From: Amanda Scholes on behalf of Planning.Responses
Sent: 06 December 2019 09:10
To: Planning Scanning
Subject: FW: BR/233/19/PL - 77 Aldwick Road

Many thanks for your email and I have since caught up with Simon regarding your previous correspondence. I also managed to visit the site yesterday and have had an opportunity to review the submission and planning histories to the site. To be clear the issues outstanding at this stage that will be reflected in any subsequent report/decision comprise: (1) Daylighting, (2) Levels of outlook/overbearing impacts, (3) Impacts upon privacy of properties along Stocker Road; and (4) Planning balance. These matters are addressed in the subsequent response below. I understand your concerns regarding the change of case officer throughout the application period but want to re-assure you that this re-allocation is to ensure your decision is expedited as per your previous requests to provide an effective service.

REAR
PROPOSED ELEVATIONS
Scale 1:100

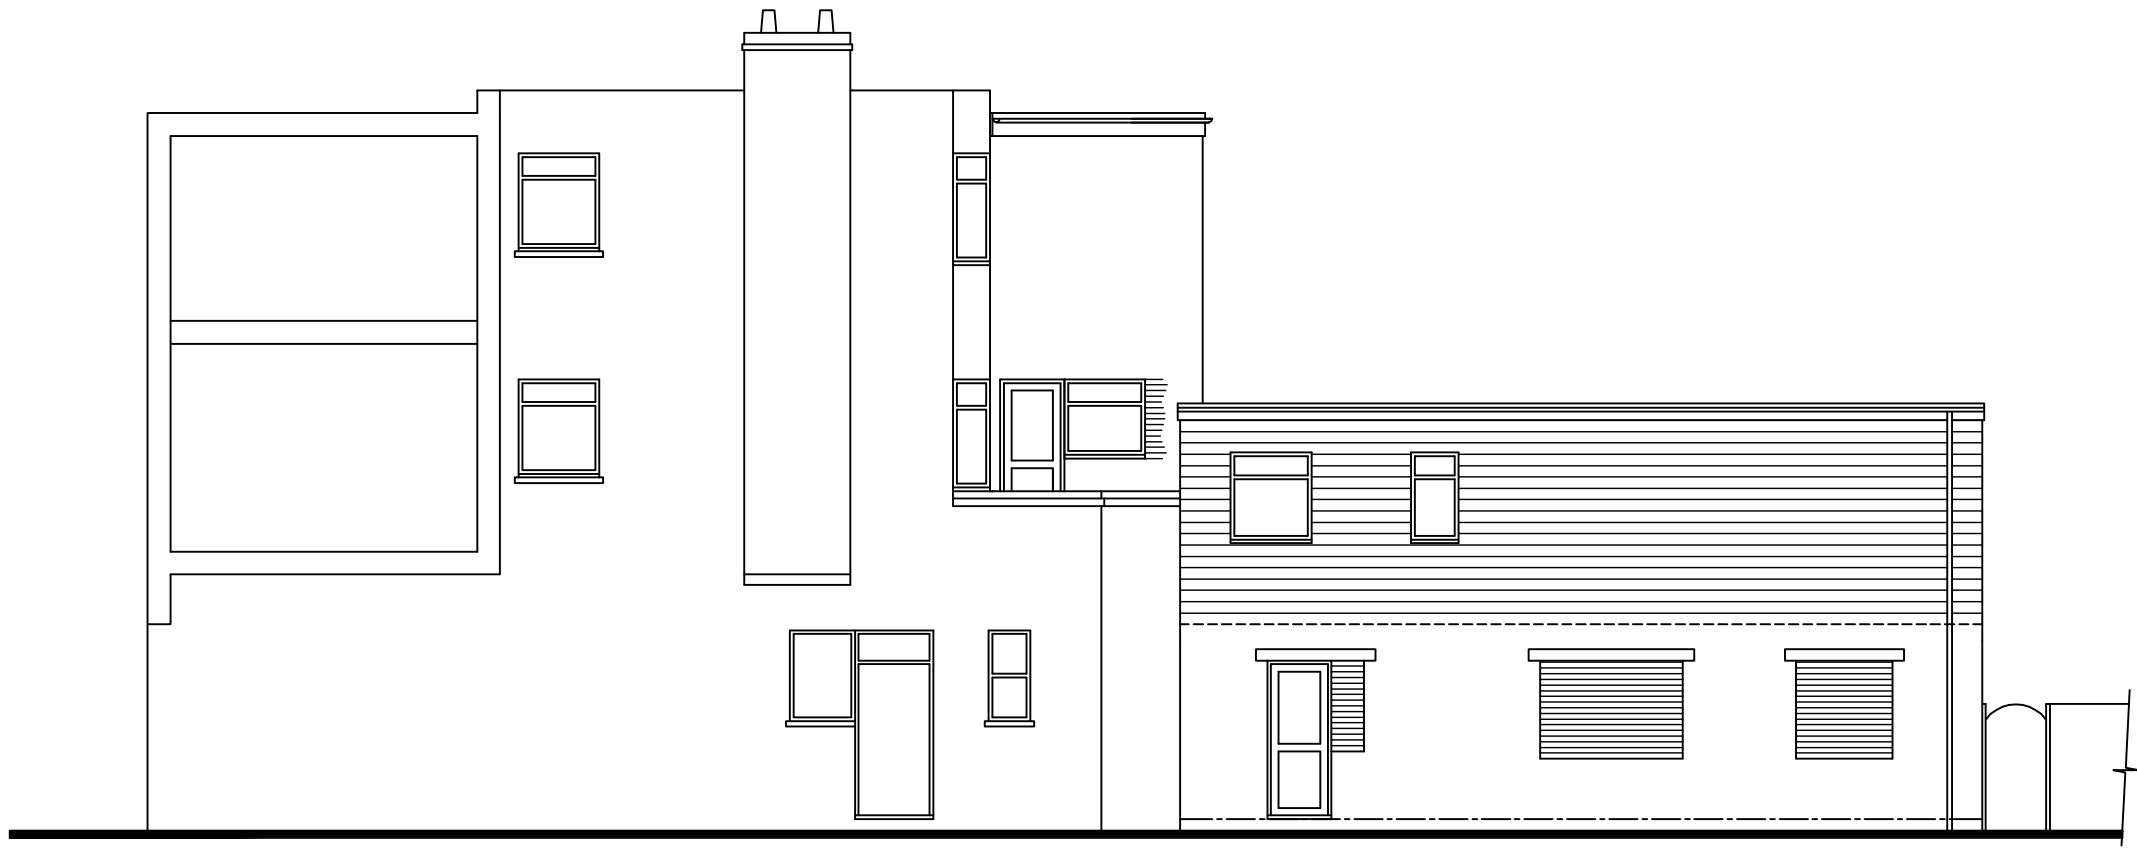
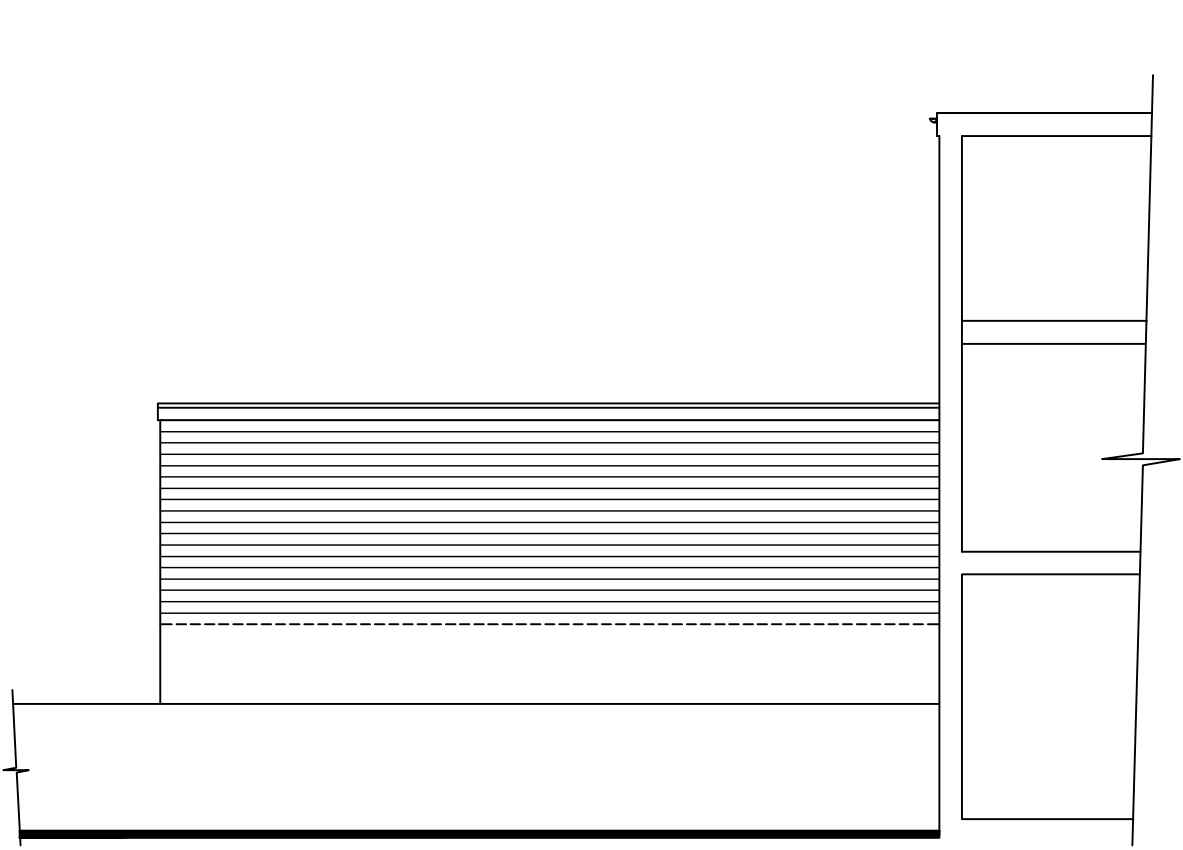
Simon has previously outlined in correspondence his concerns regarding the harm the first floor apartment creates on the amenities of neighbouring properties. I too share his concerns in respect of the perception of overlooking and overbearing impacts, specifically in relation to the impact on the first floor windows of adjacent properties and the outdoor amenity spaces (terraces) on the application building and adjacent first floor properties.

The above is particularly the case having in mind the higher finished floor level in the existing building when compared with the new extension, therefore rendering the extension very much subordinate and lower in profile views from the affected window(s). The effect of the difference in floor levels is clearly shown in the side elevation / section drawing that we have submitted.

I have attached to this e-mail a quick overlay of the VSC test as applied to the western elevation (i.e. a vertical section showing the 'affected' window) of the proposed development. The VSC test has been carried out using the centre point of the lowest window as per the BRE guidance (and also using the 2m from FFL as is also commonly used). Both VSC lines comfortably sit well above the proposed extension meaning that the diffused daylight is, quite simply, not going to be adversely affected. On this basis, an assessment using universally applied BRE methodology supports our case that there would not be an adverse impact.
